APPENDIX D: AGENCY COMMENTS ON RESPONSE TO SUBMISSIONS

Springvale Mine Extension Project - Response to Submissions

**Response to Submissions for the Springvale Mine Extension Project
SSD 5594 MOD 1**

Springvale Colliery Extension Project Modification 1 (SSD 5594 MOD 1) Comment on the Response to Submissions

Figure 5 – High priority groundwater dependent ecosystems in the Sydney Basin Richmond Groundwater Source
(obtained from <http://www.legislation.nsw.gov.au/#/view/regulation/2011/111/app2>)

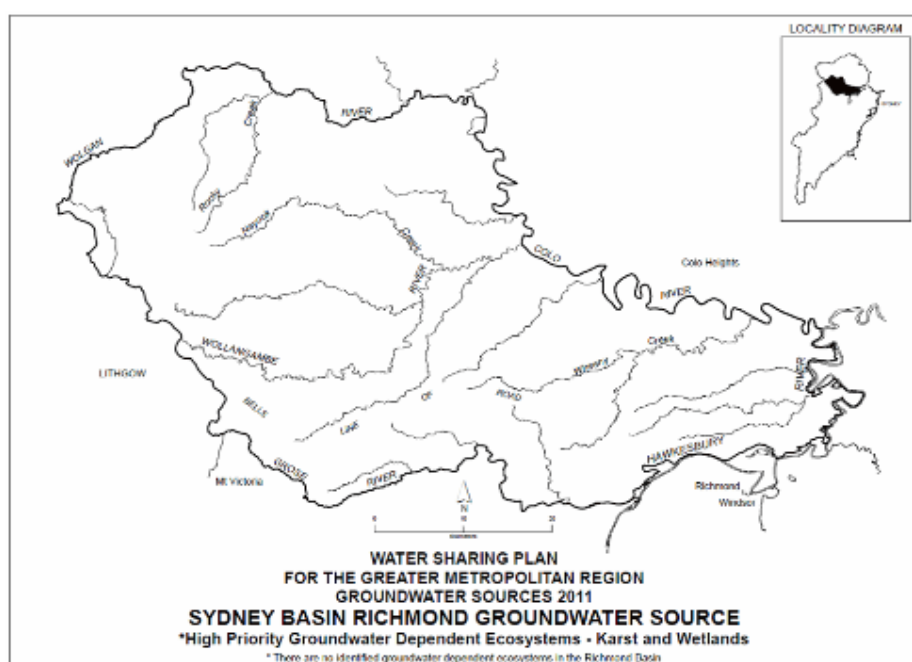
The Proponent has consistently misstated that their mining lease is not subject to any notified high priority dependent groundwater ecosystems as listed in the WSP. This is incorrect; the Proponent in searching for descriptions of the ecosystems has relied solely on WSP maps, which is inconsistent with their considerable effort regarding swamp management on the Newnes Plateau. The Proponent has stated:

As per the annotation in **Figure 2.2**, it is stated, in that figure, that there are no identified groundwater dependent ecosystems in the Richmond Basin. It is now apparent that the annotation to this map is inconsistent with Schedule 4 of the Water Sharing Plan.

DPI Water recognises that there is a difference between groundwater source map and text in the WSP, however, the matter is clearly stated in Table D of Schedule 4 of the WSP.

We acknowledge that Schedule 4 of the Water Sharing Plan does include the THPSS and appreciate the clarification. We will amend our subsequent documentation accordingly.

Figure 2.1 : Predicted Mine Inflow Rates (adapted from Adhikary and Wilkins (2013), Adhikary and Wilkins (2015) and Adhikary (2016))

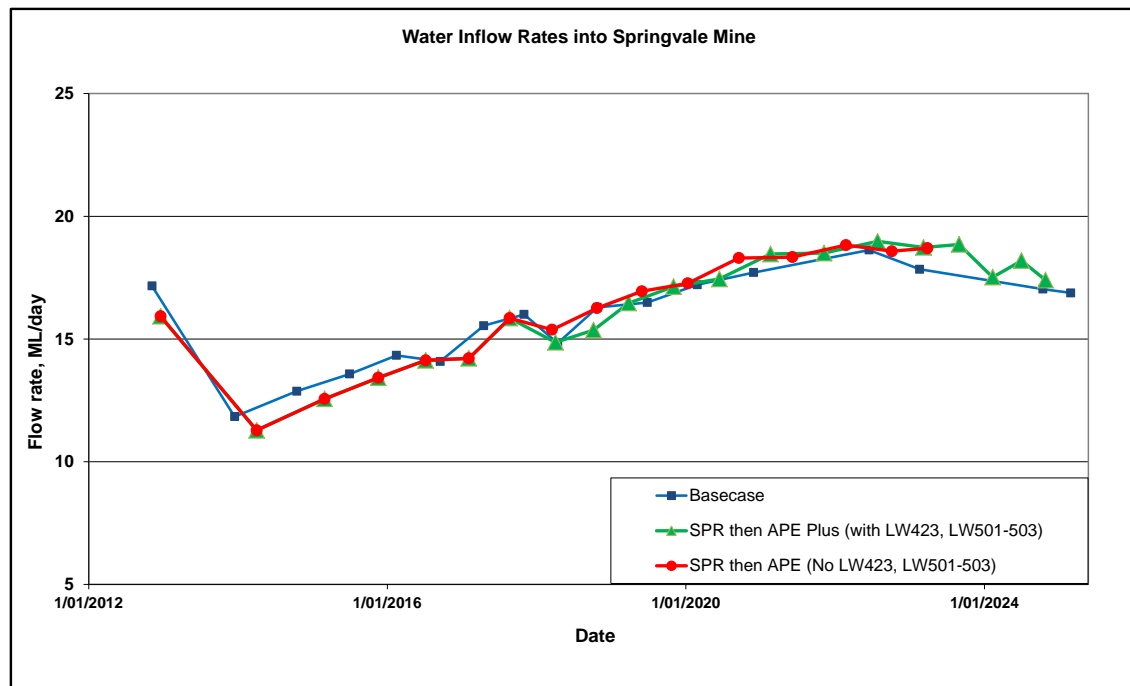
The Proponent has re-run their COSFLOW NGM for the correct mine layout and generated the necessary outputs. The outputted results now properly reflect the approved mine layout, irrespective of any business reason to exclude them (see Appendix C for an enhanced discussion). The previous work was erroneous and poorly explained. The revised outputs are shown in Figure 1 and are very similar to the original. Following this, the Proponent's analysis of the results depicted in Figure 1 is presented.

DPI Water accepts this analysis.

- The mine inflow results presented for the 'SPR then APE Plus' simulation, which included all approved longwalls at Springvale Mine under SSD5594, are consistent with the original 'SPR then APE' case (Adhikary and Wilkins, 2015) and the CSIRO (2013) predictions (Adhikary and Wilkins, 2013) which assessed the entire mine footprint. Maximum mine inflows for the three simulations are provided below:
 - The maximum mine inflows for the 'Basecase' (Adhikary and Wilkins, 2013) is 18.6 ML/day in 2022
 - The maximum mine inflows for the 'SPR then APE' case (Adhikary and Wilkins, 2015) is 18.8 ML/day in 2022
 - The maximum mine inflows for the 'SPR then APE Plus' case (Adhikary, 2016) is 19.0 ML/day in 2022.
- The Springvale Mine Extension Project EIS (Section 10.2.3.1) notes the maximum mine inflow for the whole mine plan, the 'Basecase', as approved, as 19 ML/day in Year 2022.
